From: Joshua Catt [REDACTED]
Sent: 01 May 2019 09:51
To: Daniel Vick
Cc: Laura Gibbons
Subject: RE: AL/36/19/DOC

From: Daniel Vick <Daniel.Vick@arun.gov.uk>
Sent: 26 April 2019 10:05
To: Joshua Catt [REDACTED]
Subject: AL/36/19/DOC

[Engineers Comments Regarding Condition 4- surface water drainage](#)

SKOL
PROPOSED S.I. WORKS
TP/CH LOCATIONS

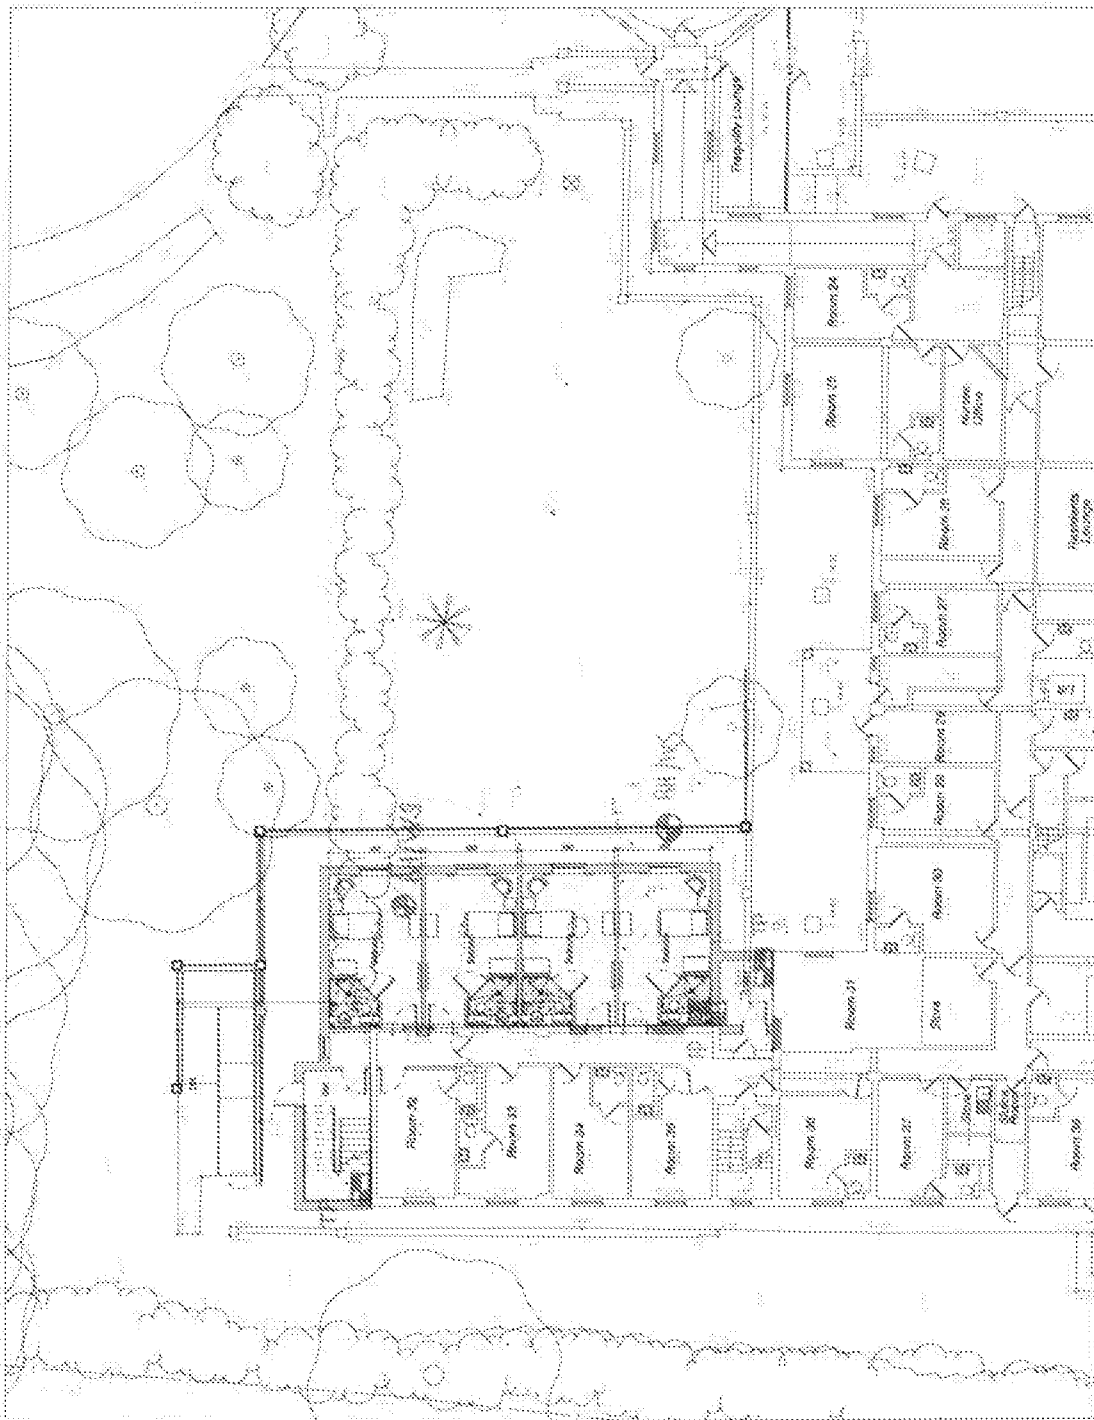
1. Please can a layout plan be provided which shows the location of the trial holes and groundwater monitoring points. The map provided does not include hole numbers.
2. The layout plan will need to be updated to include invert and cover levels of the soakaway.
3. Construction detail drawings need to show 100mm coarse sand bed and surround, and permeable geotextile.
4. Please provide construction detail drawings of pipe bedding and surround.
